From: Anita Gardner
Sent: 06 September 2018 15:22
To: Planning.Responses
Subject: FW: A/23/18/DOC - Broadlees, Dappers Lane, Angmering

From: Mark Warwick
Sent: 05 September 2018 17:12
To: Anita Gardner
Subject: A/23/18/DOC - Broadlees, Dappers Lane, Angmering

TREE PROTECTION (Plan 3A)

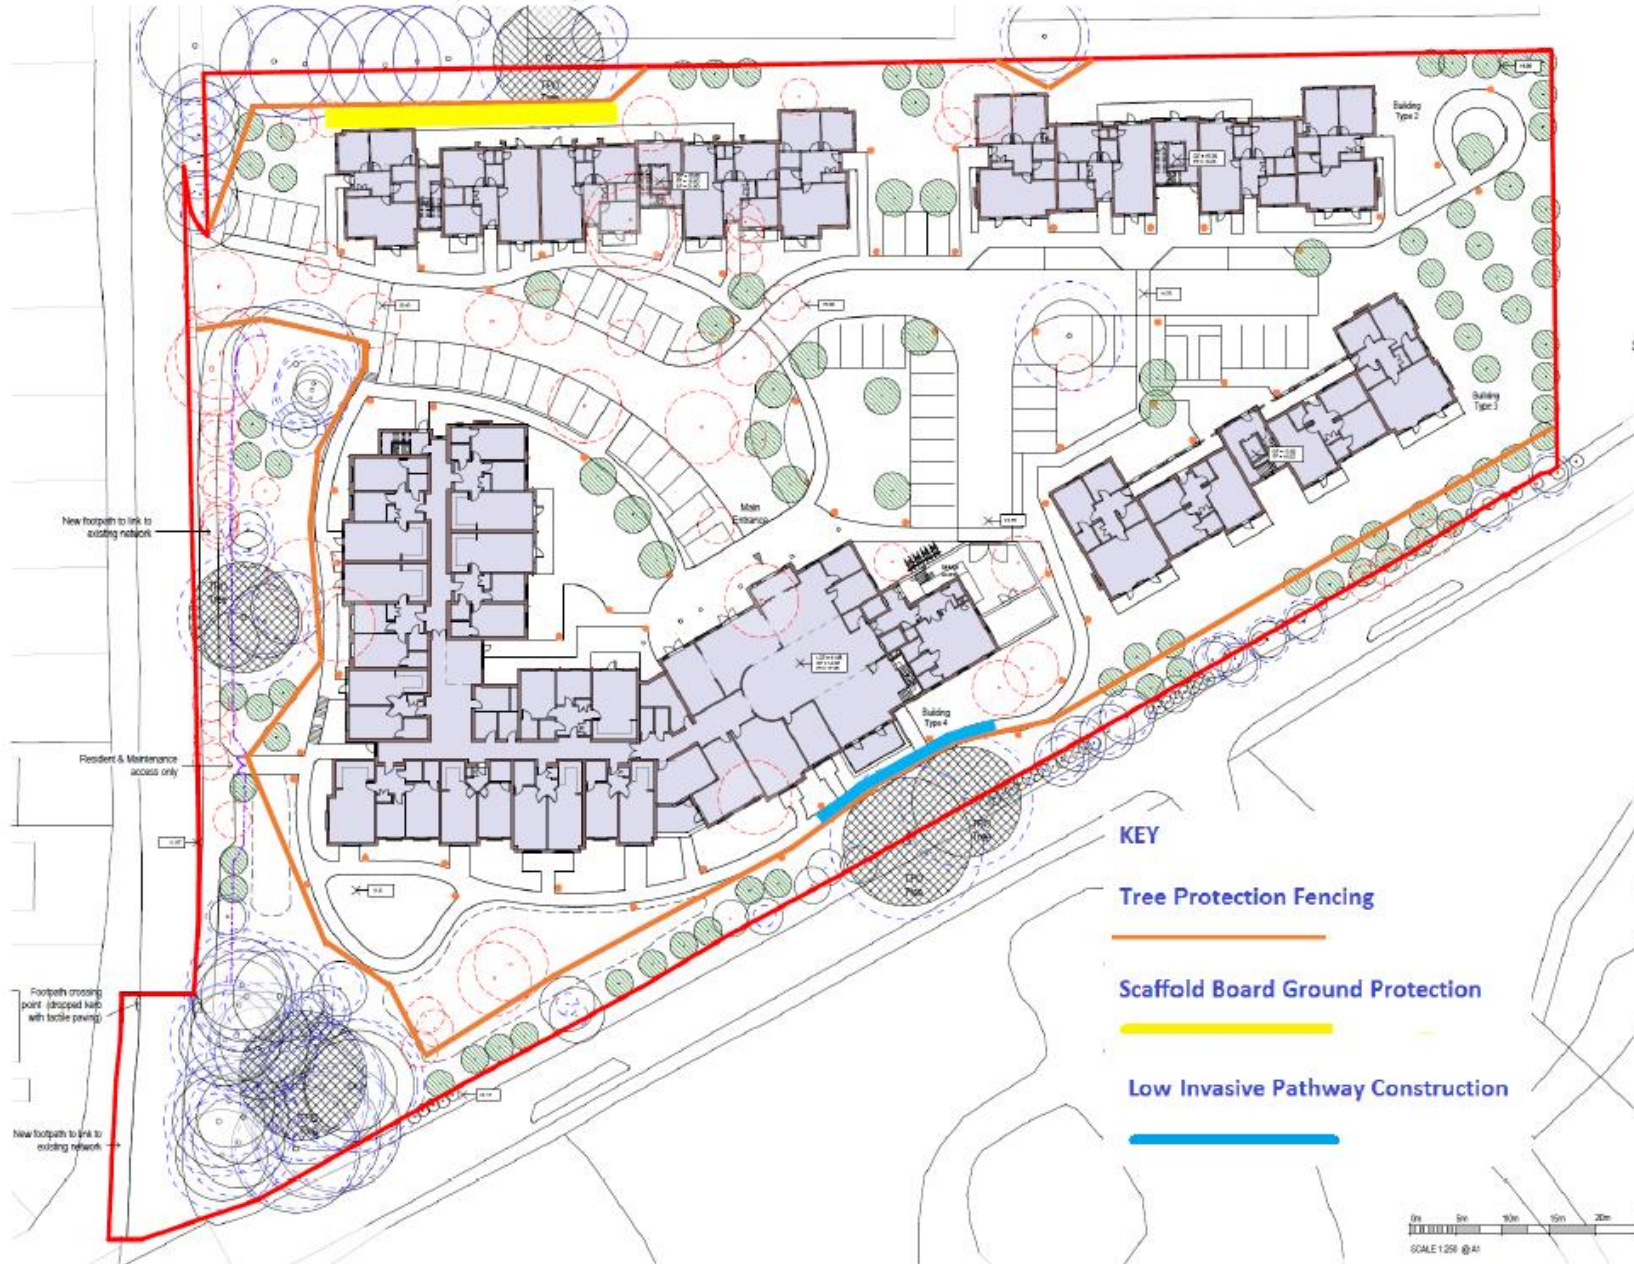
1. There is a gap in the fencing (mesh panel required) which permits access to trees, at least one of which appears to be the subject of an Order (TPO). This needs to be secured so as to provide an effective Construction Exclusion Zone and remove potential for soil contamination/disturbance.
2. Ground Protection as shown in Plan 3A is absent at the NW corner of the site. Again, there are trees of value here at least one of which appears to be the subject of an Order (TPO). This needs to be in place before I am comfortable that any demolition work can proceed.

They are almost there, but presently it falls short of providing adequate protection for the most significant trees retained on site.
